2019  
**Site Address:** 29 Blackthorn Avenue Felpham PO22 8GA  
**Grid Reference:** 496235 100924  
**Description of Works:** Single storey rear extension, re-siting of boundary wall & new vehicular access.

## WEST SUSSEX COUNTY COUNCIL CONSULTATION

| <b>SUBJECT:</b>                 | FP/27/19/HH<br>Single storey rear extension, re-siting of boundary wall & new vehicular access.                                                                                                                                            |

PROPOSED BOUNDARY WALL AND VEHICULAR ACCESS AT 29, BLACKTHORN AVE., FELPHAM
FOR MR. & MRS. A. CONNOR.

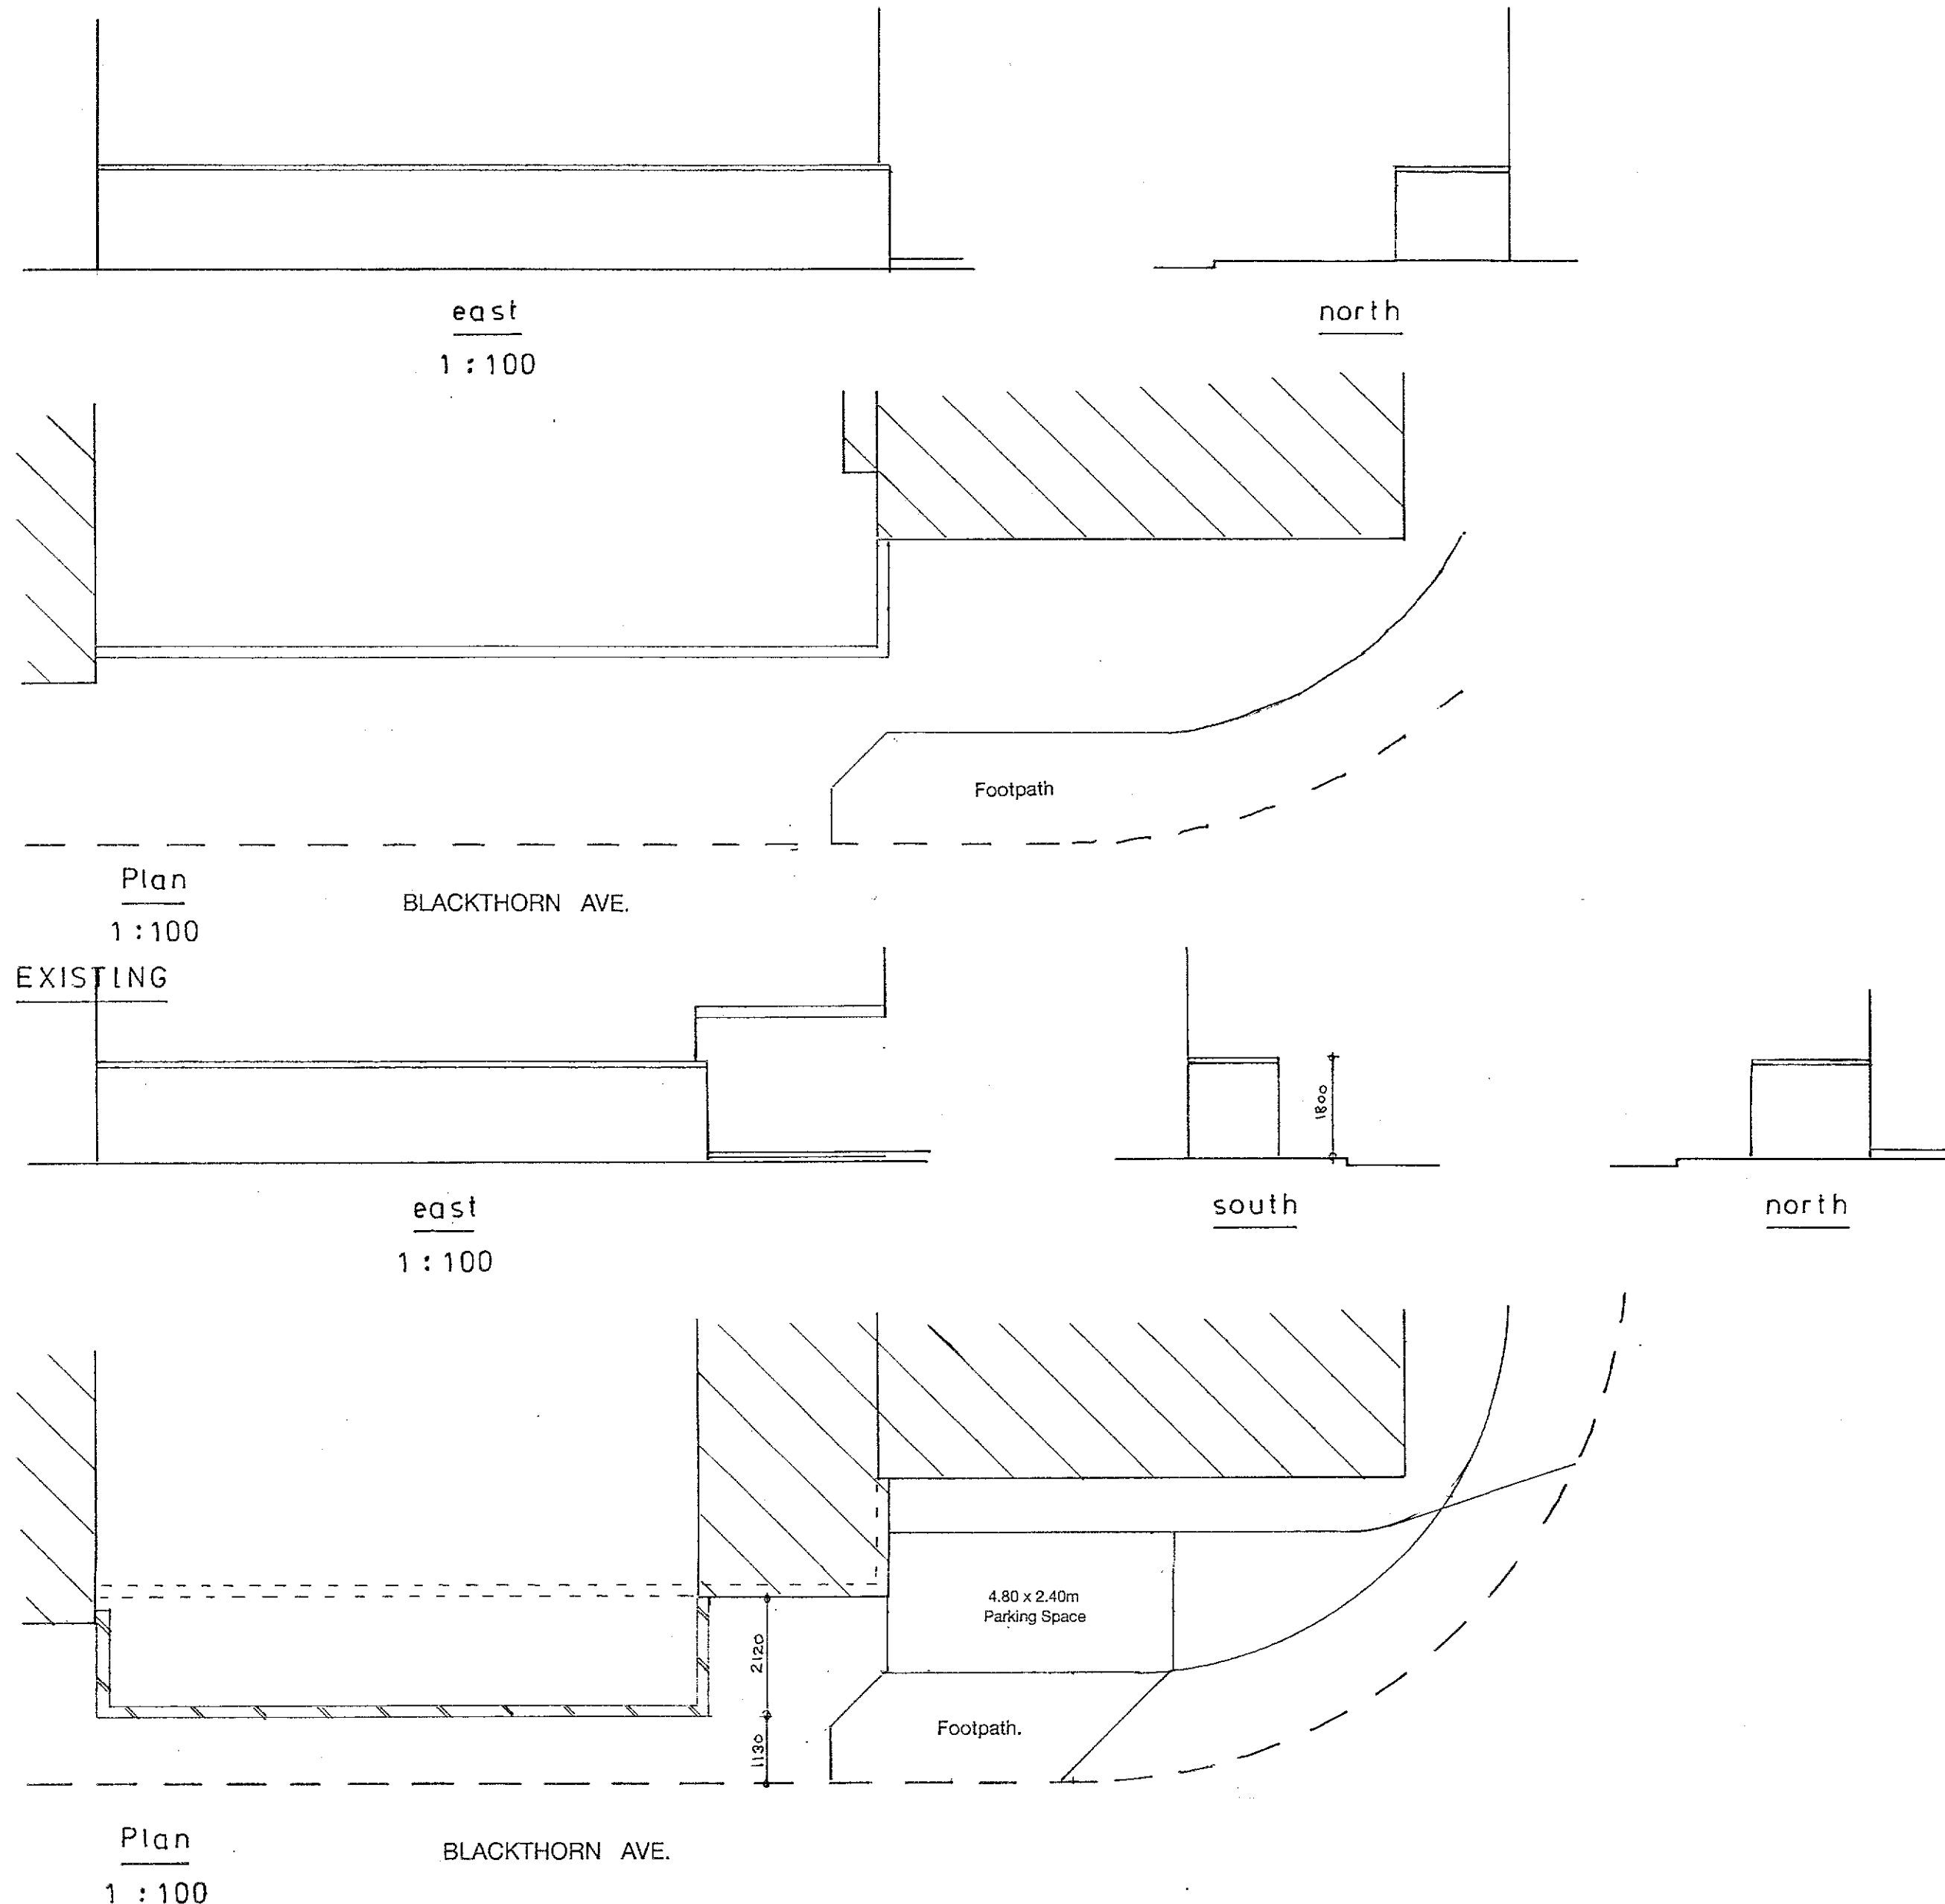
Local mapping indicates that the kerb is dropped to the east of the site where the access is proposed, with the presence of tactile paving, to facilitate pedestrians. However, on site it was observed that this kerb has since been reinstated and the tactile paving removed. No vehicular access currently exists on the site - the applicant is advised to contact the proprietor of Blackthorn Avenue to obtain formal approval for the proposed site access works and to ensure that the proposed vehicular access is constructed to a sufficient standard. The LPA are also advised to contact the developer in regards to the proposals.

Visibility has not been demonstrated at the proposed site access. The LHA would advise that maximum achievable visibility is conditioned at an X distance of 2m to ensure that the re-sited boundary wall does not impact upon visibility. On site it was observed that there is extensive on-street parking in this location; and in addition to the proximity to the 90° bend in the road, road speeds are anticipated to be slow in this location.

The proposed plans indicate that the re-sited boundary wall will not encroach on the verge to be adopted by WSCC.

As the applicant is proposing a parallel parking space, the LHA would expect that this space meets specifications of at least 2.4 x 6m in order to enable a vehicle to manoeuvre into the space and open

doors. There appears to be space on site to increase the width of this proposed space to provide manoeuvrability for a vehicle.

No part of the development shall be first occupied until maximum achievable visibility splays have been provided at the proposed site vehicular access onto Blackthorn Avenue in accordance with plans and details to be submitted to and approved in writing by the Local Planning Authority. Once provided the splays shall thereafter be maintained and kept free of all obstructions over a height of 0.6 metre above adjoining carriageway level or as otherwise agreed.

No part of the development shall be first occupied until the car parking spaces have been constructed in accordance with plans and details to be submitted to and approved in writing by the Local Planning Authority. These spaces shall thereafter be retained at all times for their designated use.
